From: Sue Howell
Sent: 26 April 2017 15:25
To: Planning.Responses
Cc: David Innes
Subject: RE: Planning Consultation on: BN/51/16/RES

Comment from Greenspace

APPLICATION BN/51/16/RES

Site Address: Land at former Pollards Nursery Lake Lane
Barnham

Drawing Title:
**Planting Plan
1 of 3**

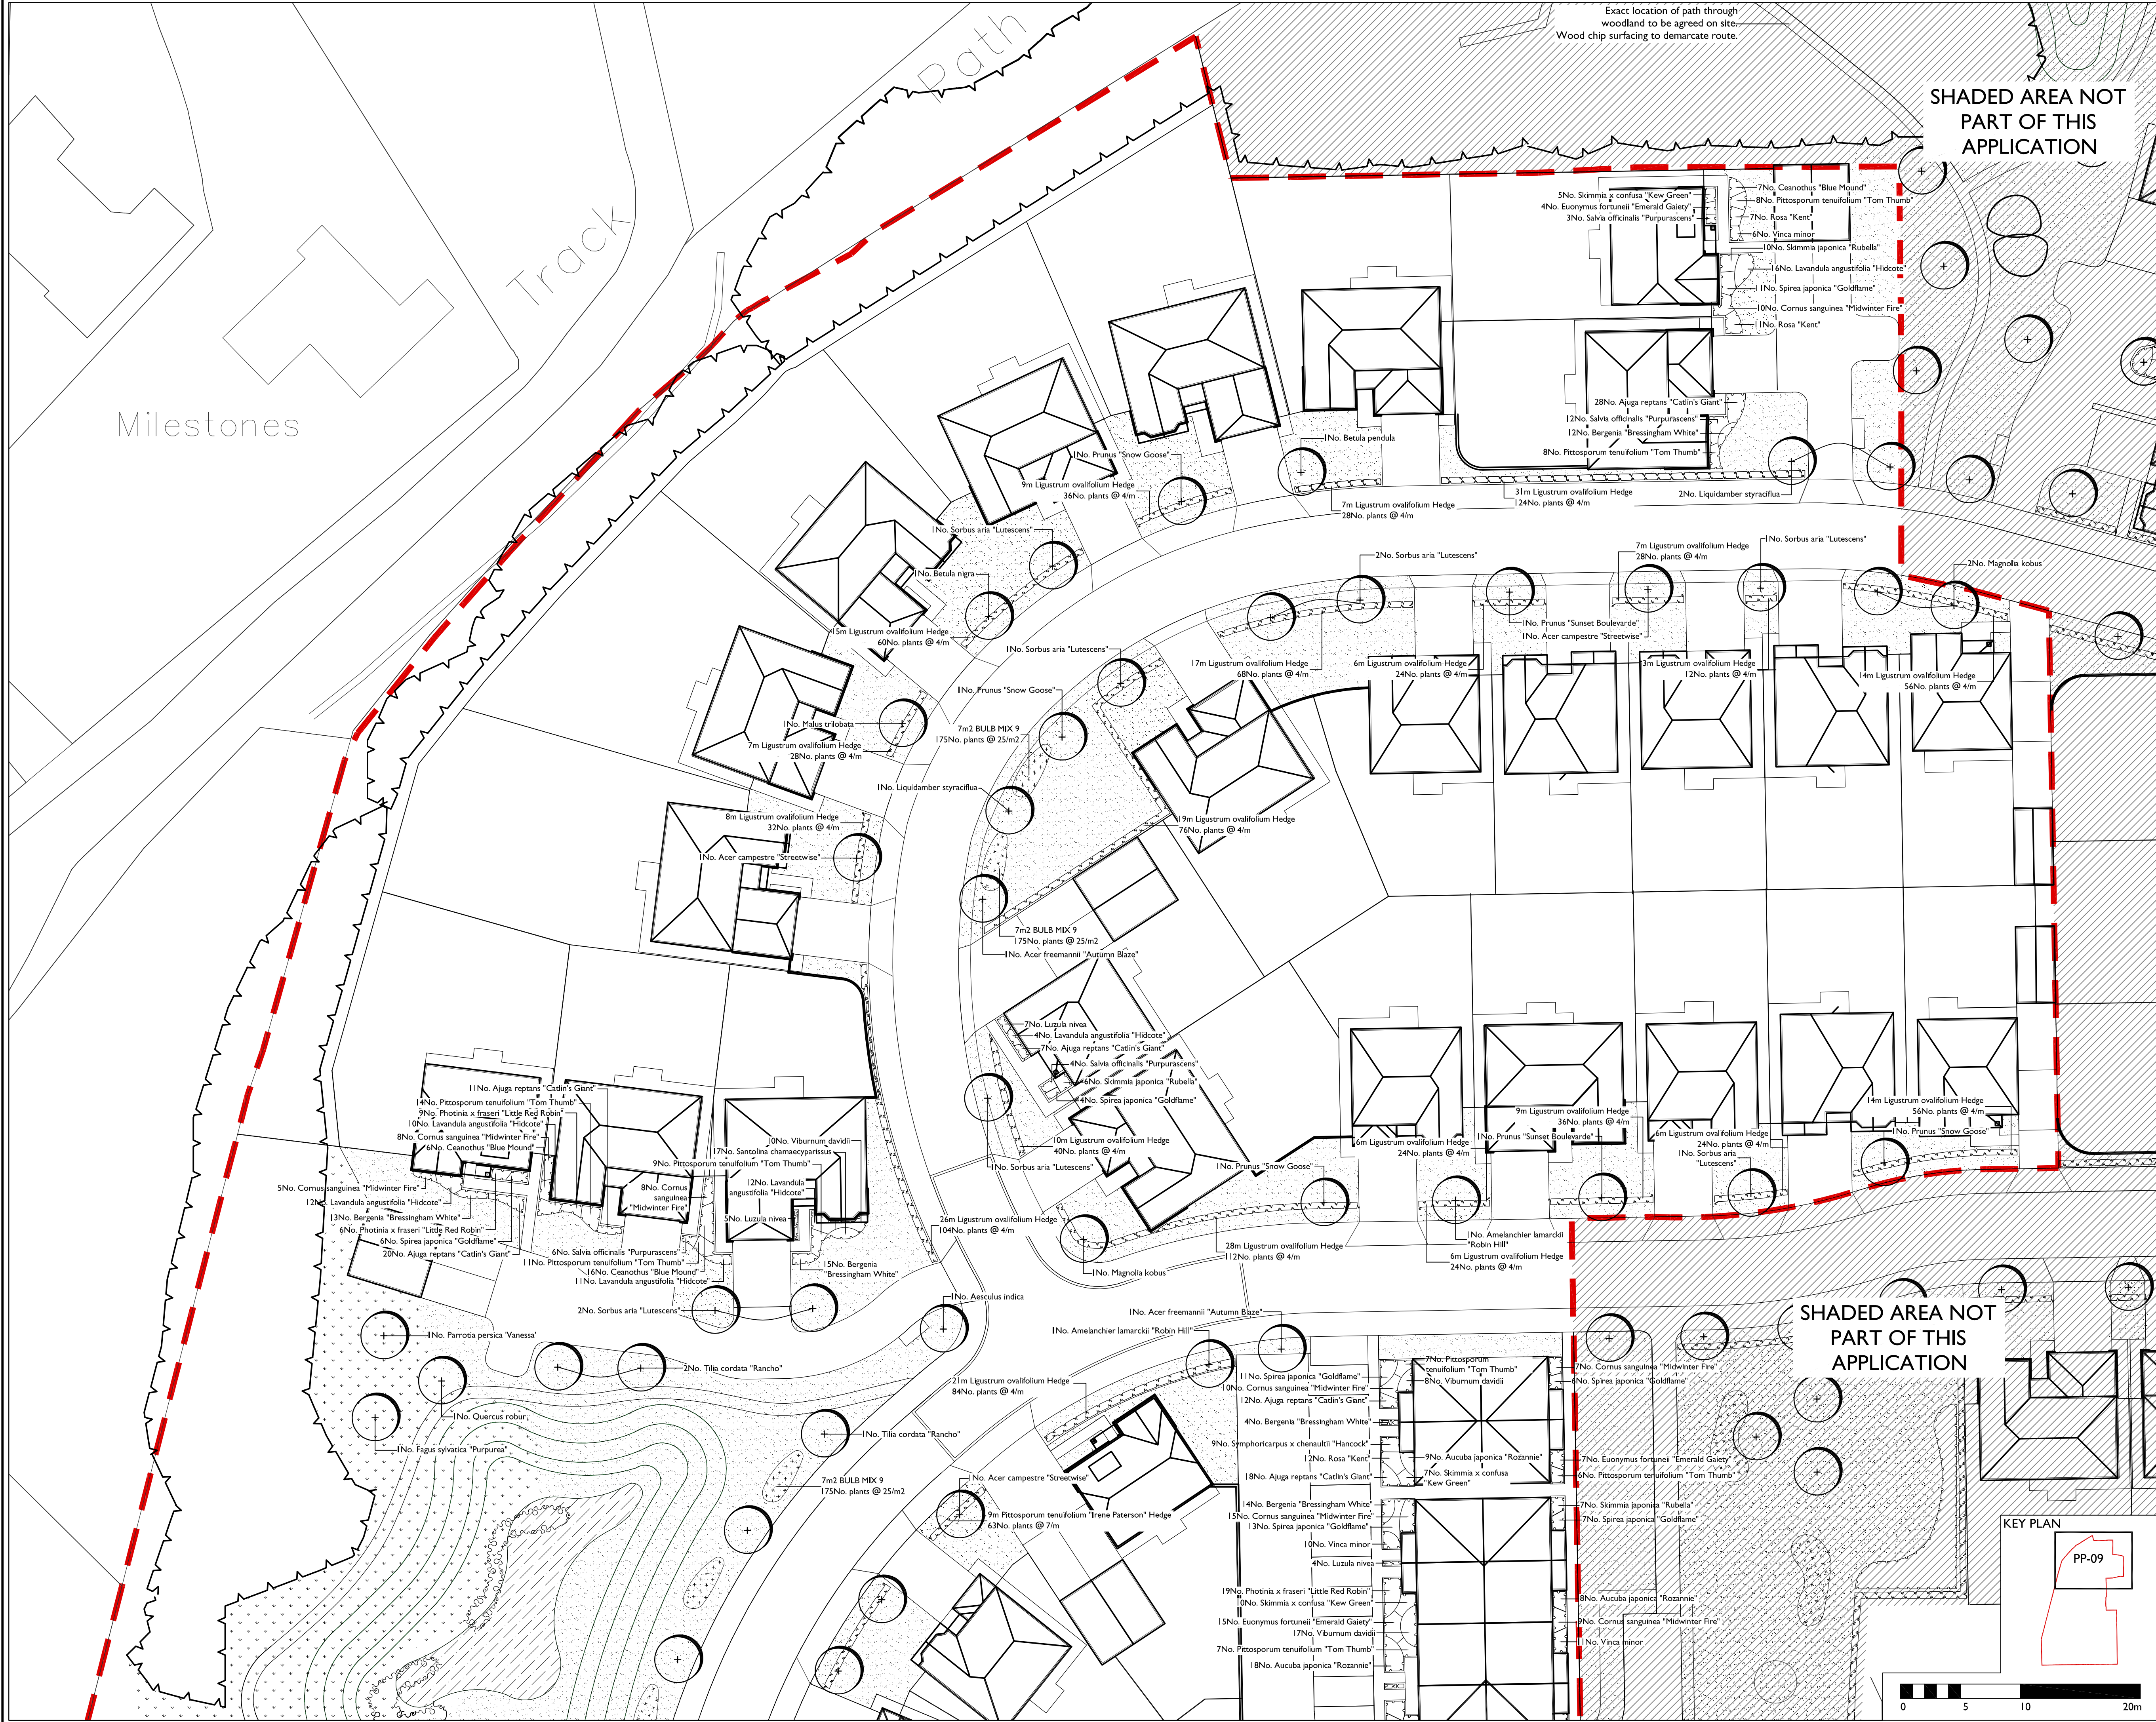
The landscape scheme proposed under this reserved matters application contained in planting plan drawings P1 of 3 2600-00-09 Rev P2, P2 of 3 2600-PP-11 Rev P2, P3 of 3 2600-PP-11 Rev P2, detailed planting plans 2600-PP-07 & 08 in general provides a good species selection of mixed native evergreen and deciduous trees, herbaceous, shrubs and hedging plants which if given the correct protection and aftercare would create a suitable scheme. The details show trees and shrubs detailed at an appropriate size which will give instant impact, screening and softening to the development. The planting detail is shown in plan form detailing species mix, planting density and size at time of planting.

The inclusion of SUDS within the POS whilst providing some biodiversity benefit may limit the useable POS area in general. Information on the cross sections of the ponds to identify the water level and space around the ponds to be ascertained also to identify any potential impact on adjacent trees. The trees particularly to the western boundary of the site are particularly significant and in order to preserve these as a permanent feature it is welcomed to see these within the POS areas rather than private gardens. Protection of these during any construction works within the site must be adhered to in line with the submitted and approved tree protection plans.
